Memorandum

To: City of Albuquerque Development Review Board

Date: September 13, 2019

Re: Comment Responses for PR-2018-001670

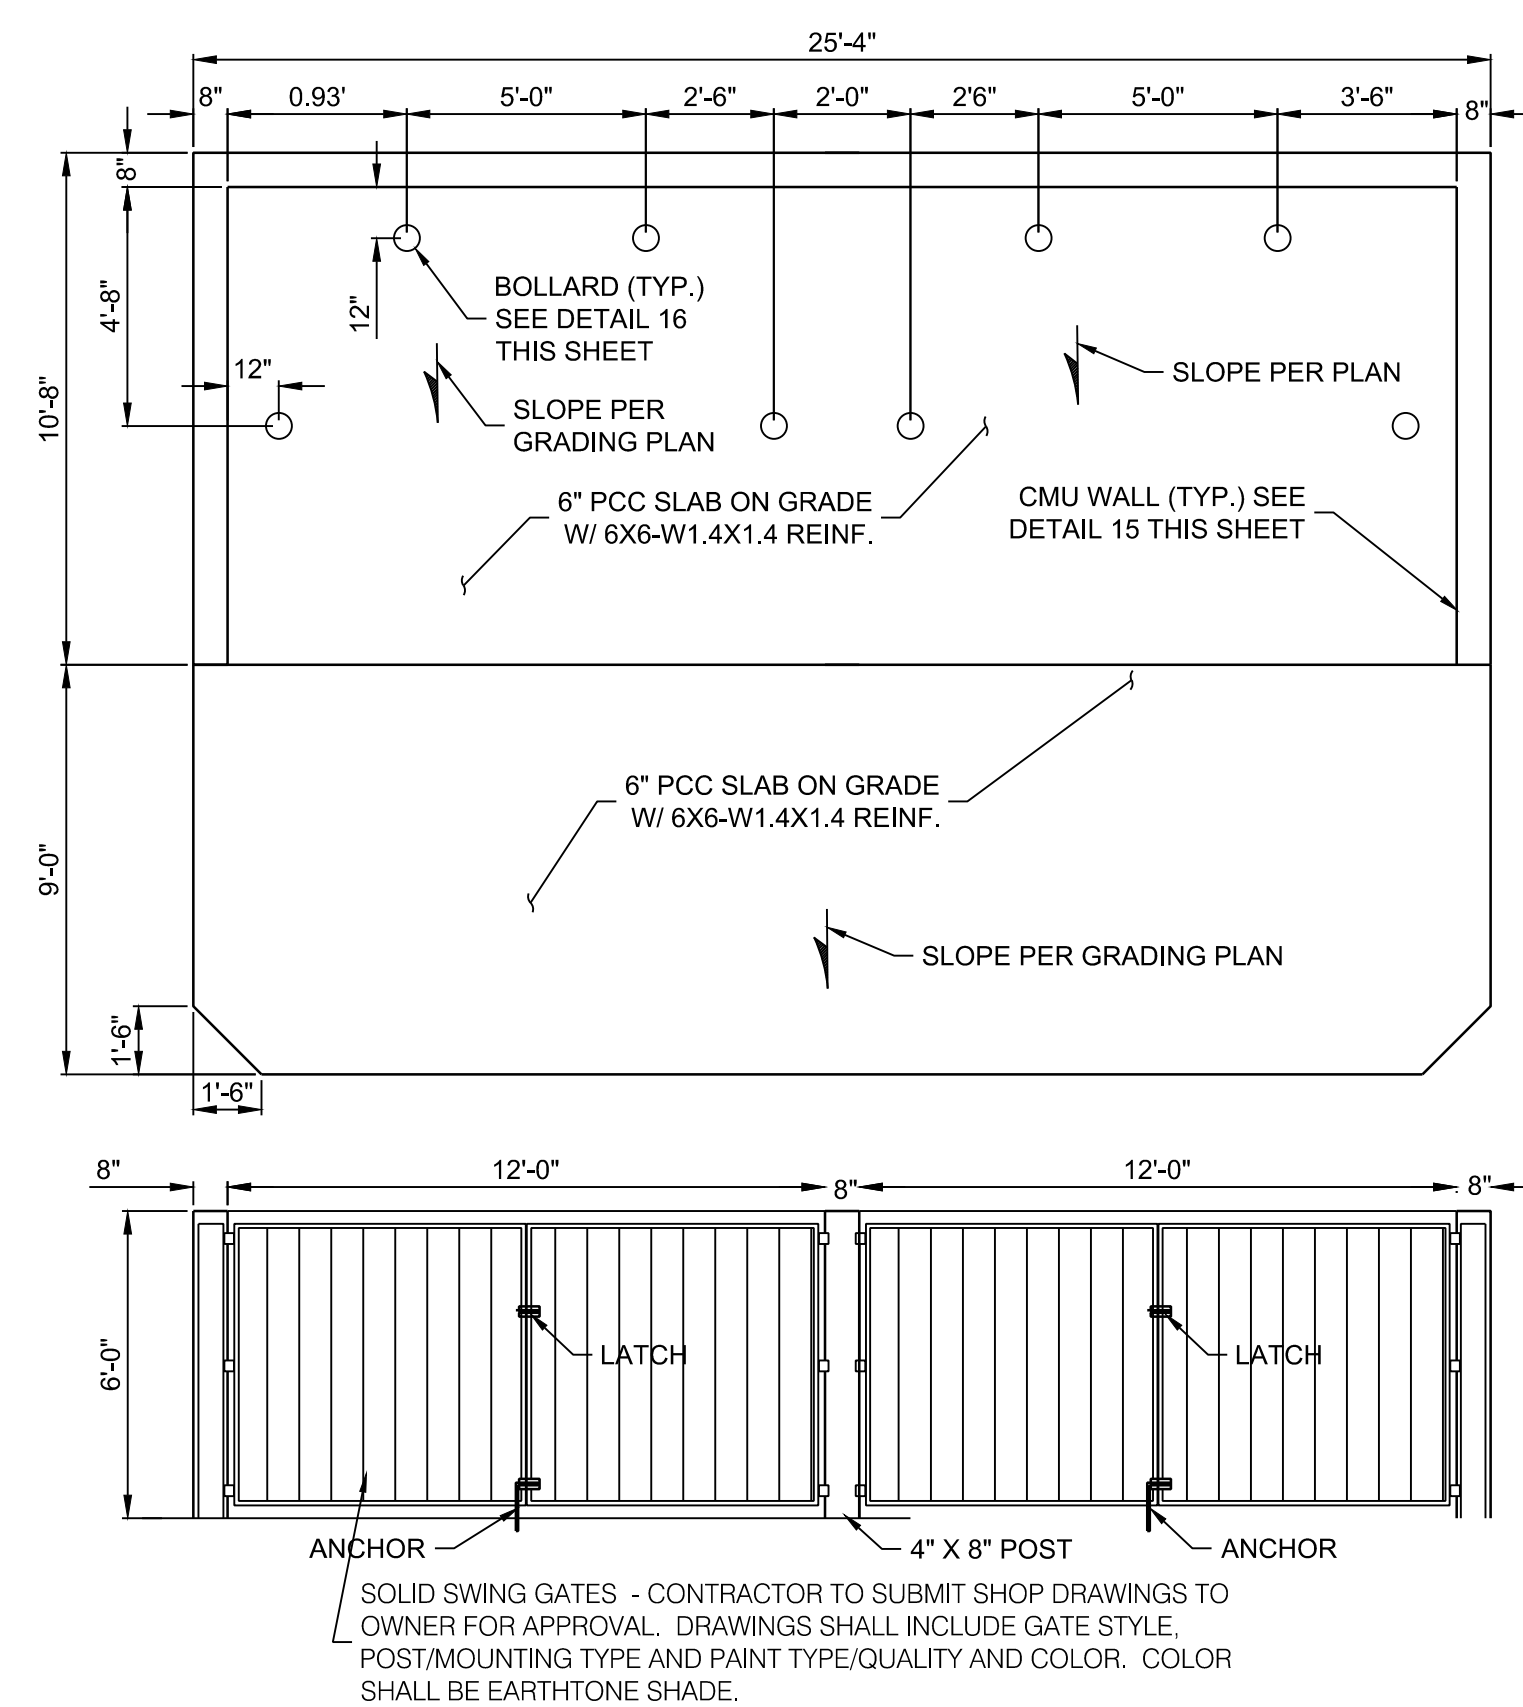
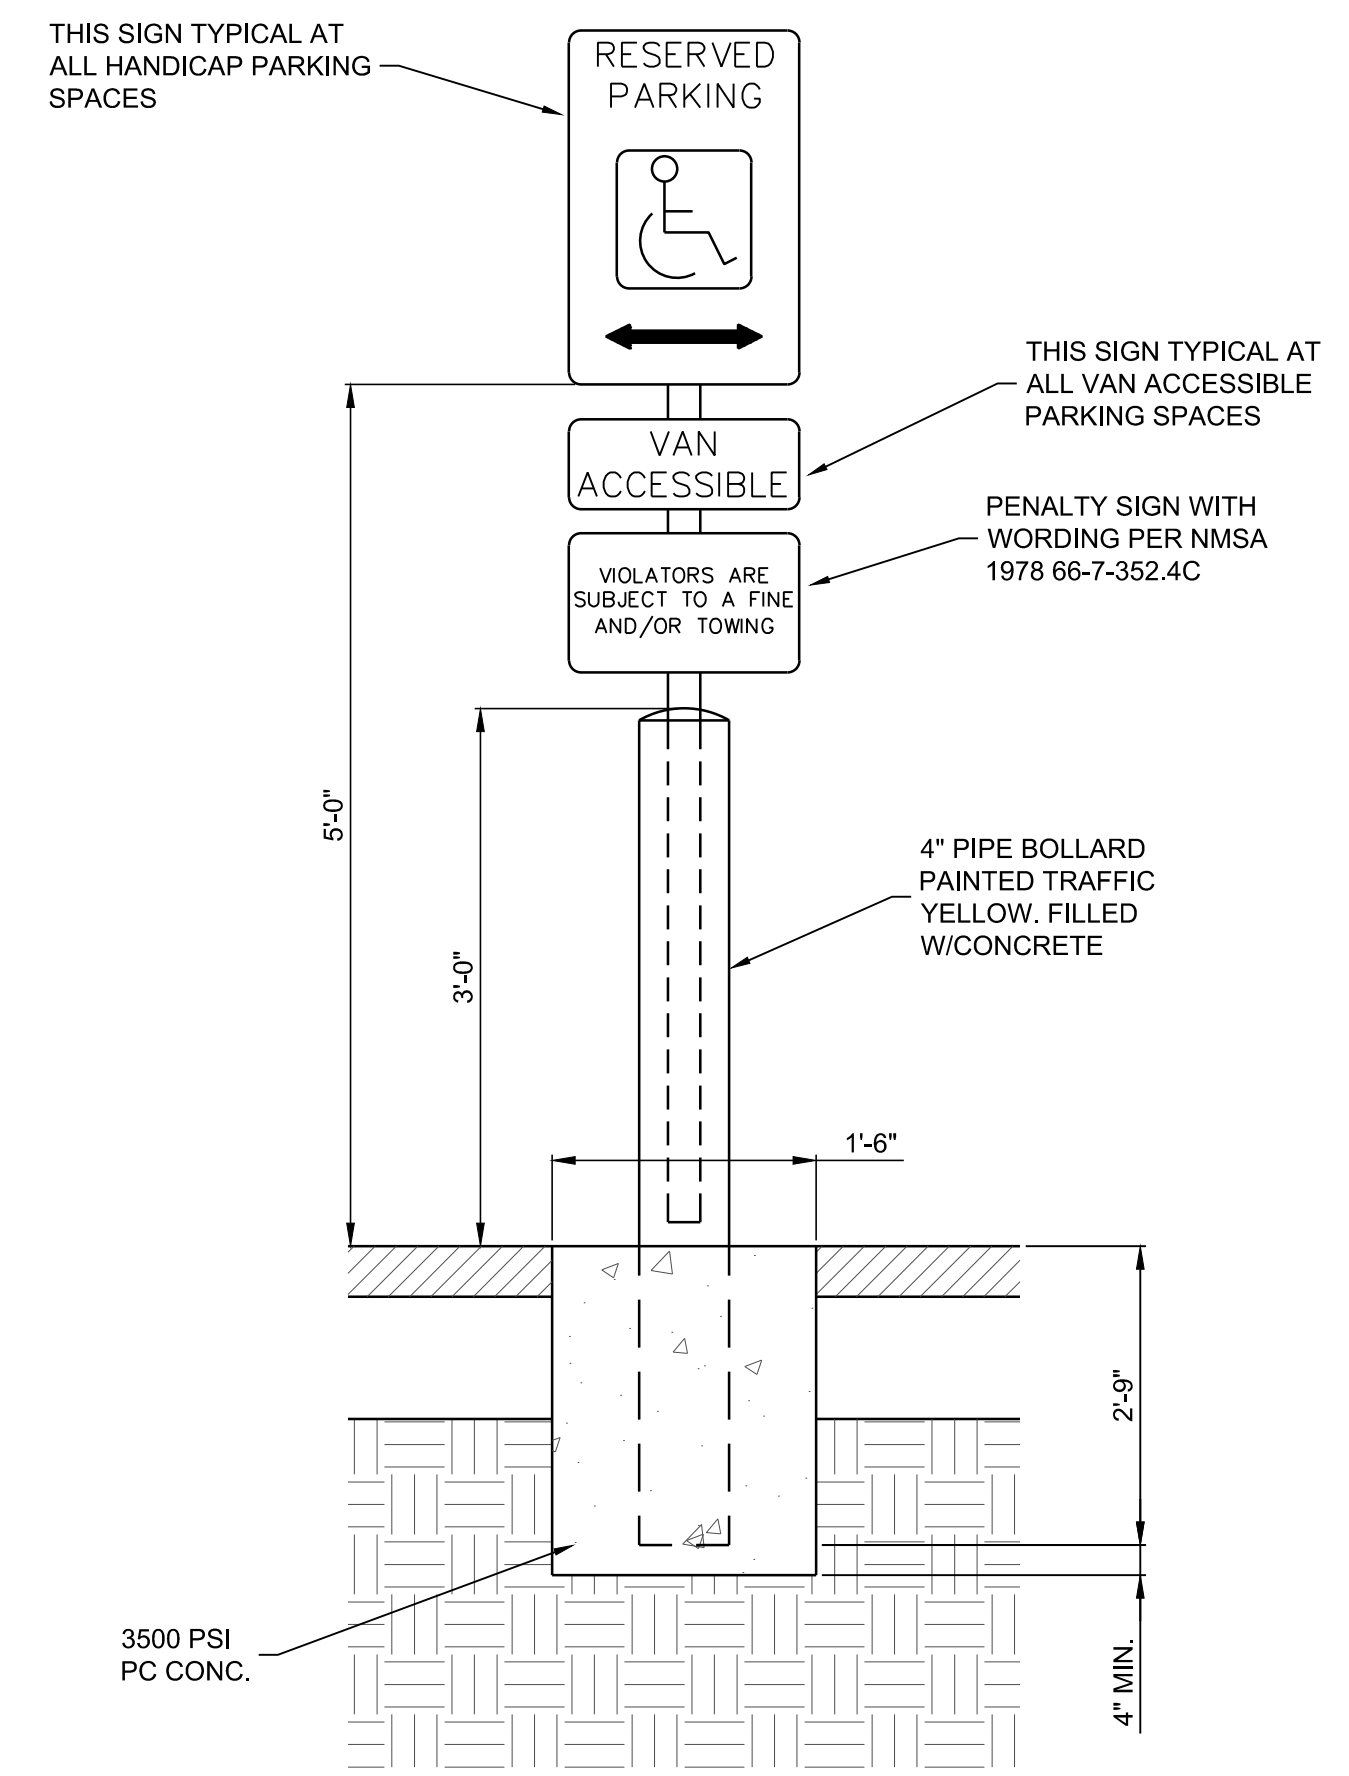
- a. *Clear sight triangles and required note added to the site plan.*
4. For the ADA's access aisle words "NO PARKING" in capital letters, these words shall be specified to be at least one foot high and at least two inches wide. The van accessible aisle dimension should be labeled as 8 feet wide.

- a. *Dimension added to site plan. Detail updated with words and dimension note.*
5. The ADA accessible parking sign must have the required language per 66-7-352.4C NMSA 1978 "Violators Are Subject to a Fine and/or Towing." If that language is present it is not visible in the detail.

- a. *Detail updated to show language as requested.*
6. Provide a copy of Solid Waste approval.
 - a. *Hard copy previously provided, and we will obtain signature on original set prior to DRB.*

NORTH ELEVATION

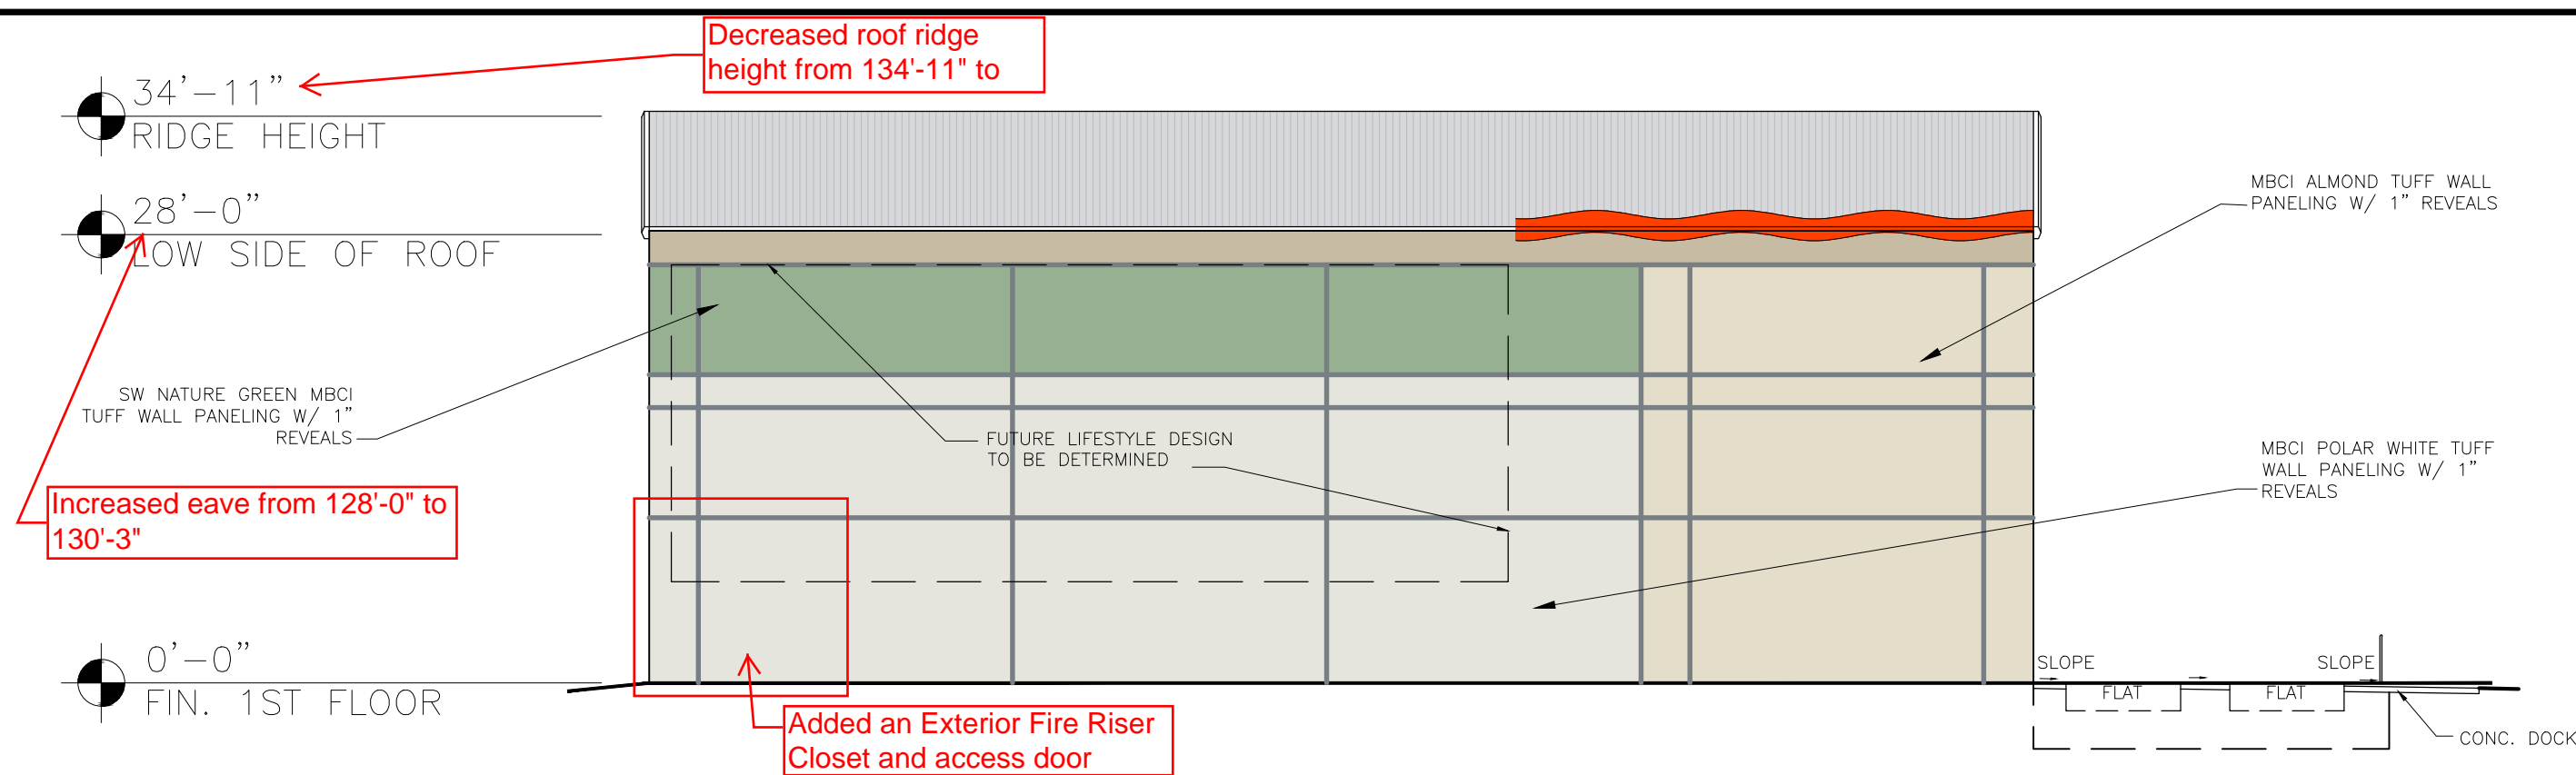
4. See section 5-11(E)(2) for façade standards – how does the building meet these standards? Were U Box elevations provided? Check north elevation of U Box and add feature to comply with section.

- a. *Building elevations will be amended to add required feature prior to and confirmed at the DRB meeting on this request, or alternatively confirmed via a condition of approval.*
